## Warragamba Dam Environmental Impact Statement- IUCN technical review

**Title of proposal:** Warragamba Dam Raising

**Document submitted:** Environmental Impact Statement (EIS) – Warragamba Dam Raising, prepared for WaterNSW, 10 September 2021

Figure 13-1. Summary of the proposed approach to implementing the Warragamba Offset Program

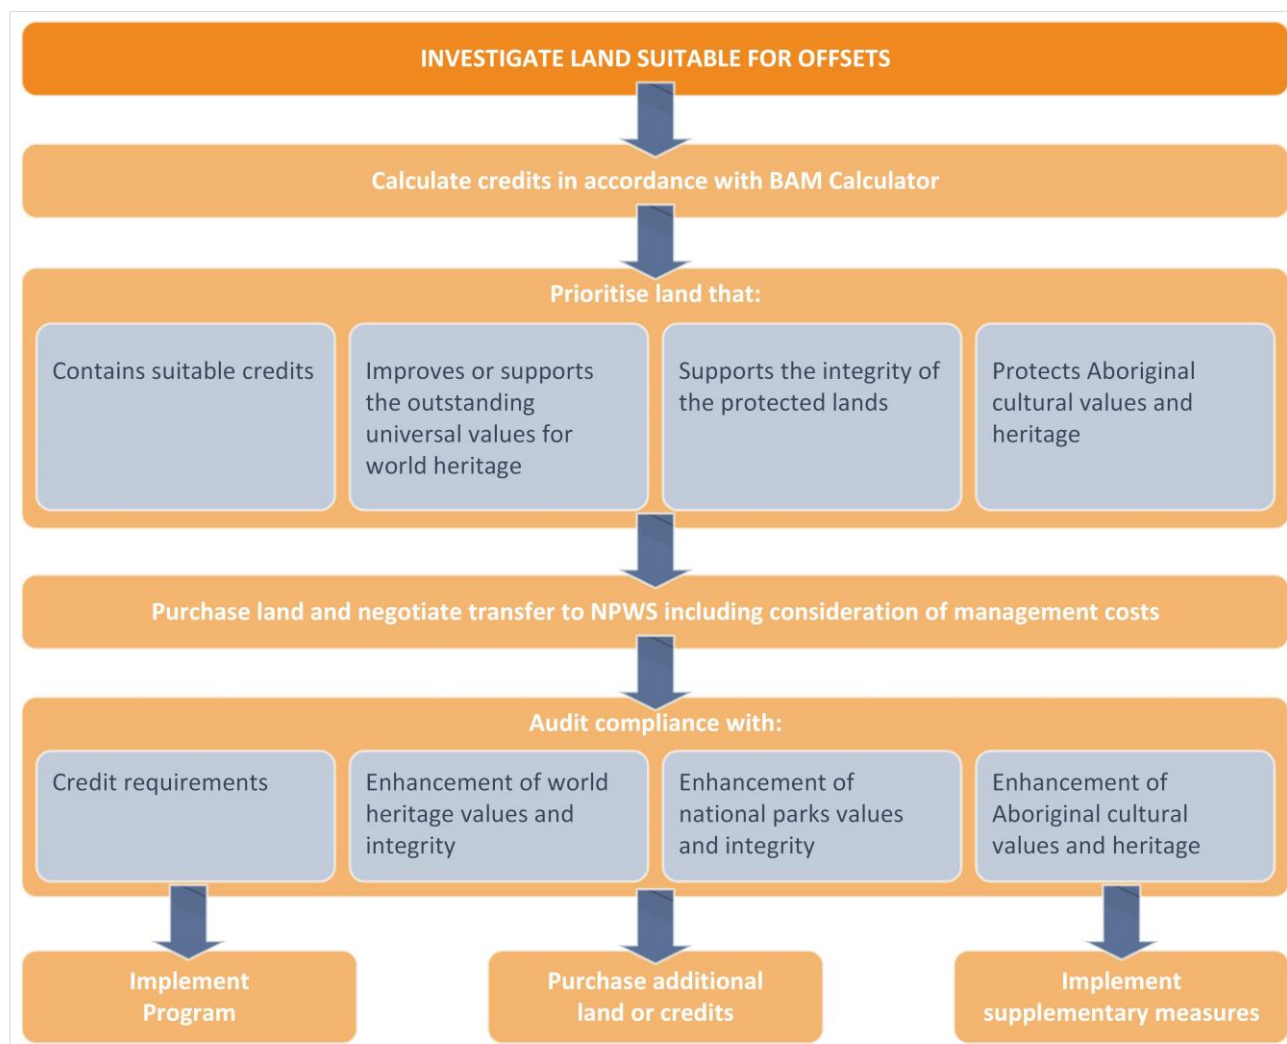
Finally, regarding the Warragamba offset program proposed in order to minimise the impacts of the project '*where impacts cannot be avoided*', it should be noted that OUV, confirmed through the inscription of the property, cannot be subject to excisions and compensation on an area basis. In principle, IUCN considers that OUV cannot be offset and therefore the concept of compensation plots for the planned loss of OUV is not appropriate.

- a. the methodology for assessing ecological impact and impact on associated cultural values that directly contribute of the OUV of the property is insufficient to assess impacts on OUV, including in light of the fires following the surveys undertaken for the assessment;
- b. local communities, including Traditional Owners, do not appear to have been adequately engaged in the development of the EIS, and it also is apparent they have not provided their free, prior and informed consent;
- c. the proposal to offset planned loss of OUV is not acceptable.
